11 November 2015

Re: Addendum to S75W modification application to MP09_0074

An application was submitted on 30 September 2015 to modify the project approval MP09_0074 for a Waste and Resource Management Facility on land situated at 123-179 Patons Lane, Orchard Hills. The application sought to modify Conditions 18 and 19 within Schedule 3 and the definition of 'Site Establishment' within Schedule 2.

Figure 4: Approved site establishment plan

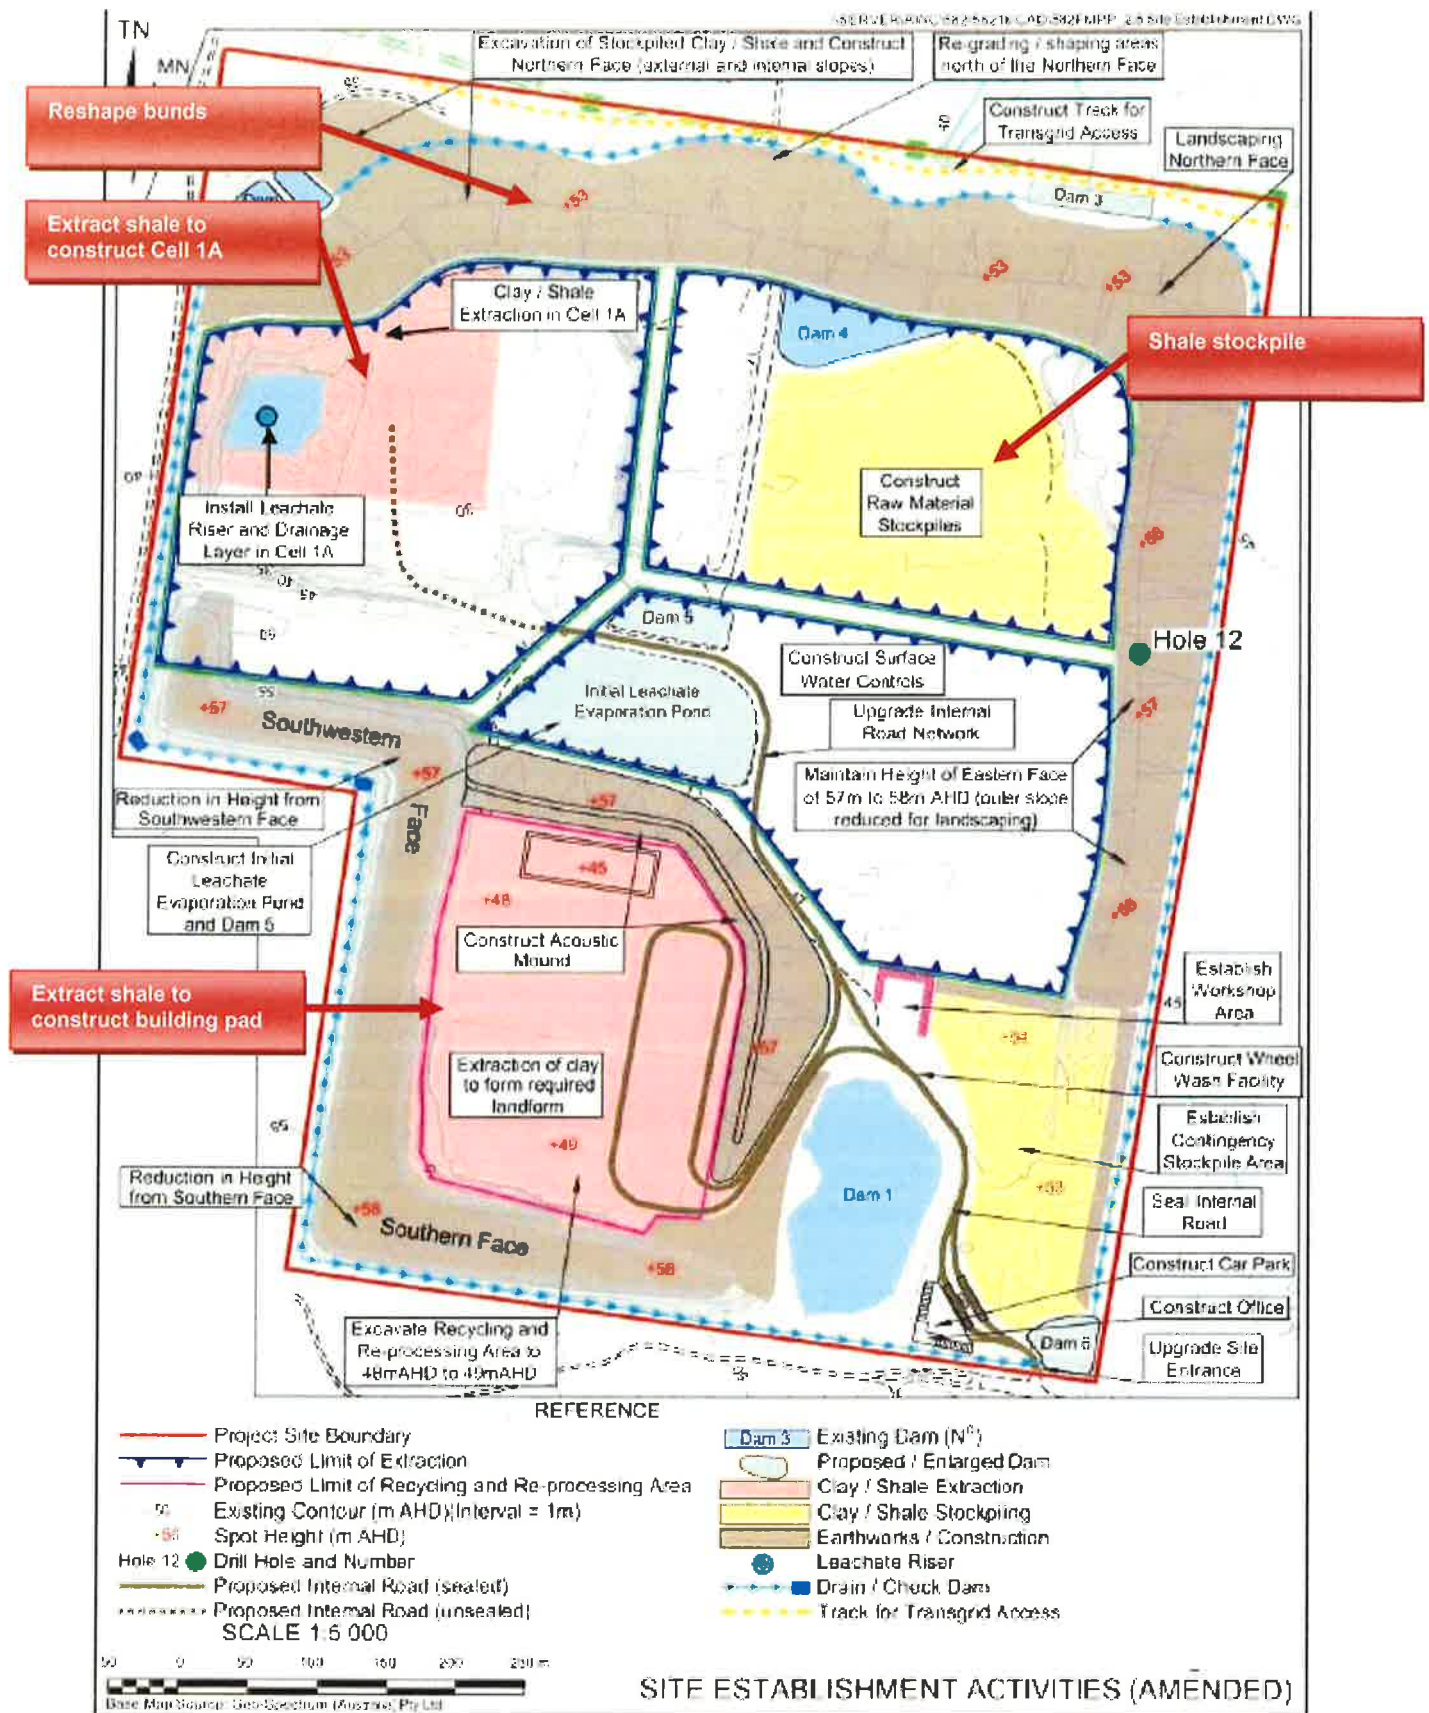
The definition of 'Site Establishment' currently refers to construction works for Cell 1 and clay/shale extraction associated with the construction of Cell 1. This is incorrect and should refer to Cell 1A.

Figure 2.6 'Site Establishment Activities (Amended)' in the 'Further Modified Preferred Project Report' (shown as Figure 2 in this addendum letter) depicts the works to be undertaken as part of Site Establishment and is also included in the definition of Site Establishment in Schedule 2. Figure 2.6 clearly shows site establishment works within Cell 1A only and not the remaining sub-cells of Cell 1. The annotations on Figure 2.6 refer to the construction of a sump in Cell 1A and the excavation of clay and shale from Cell 1A.

Given the above information, it is clear that the definition of Site Establishment should refer only to site establishment activities being undertaken within Cell 1A. Therefore, it is requested that the definition of ‘Site Establishment’ be amended to:

- initial shaping of the northern and north-eastern bund walls;
- reshaping of the southern and south-western bunds;
- emplacement of onsite waste resulting from the reshaping of the bunds described above;
- construction work for buildings and infrastructure;
- road works required by this approval; and
- construction work for Cell 1A and any clay/shale extraction associated with the construction of Cell 1A.

and as otherwise shown on Figure 2.6 ‘Site Establishment Activities (Amended)’ of the FMPPR at p18 (Exhibit Z in Appeal No 10928 of 2010).
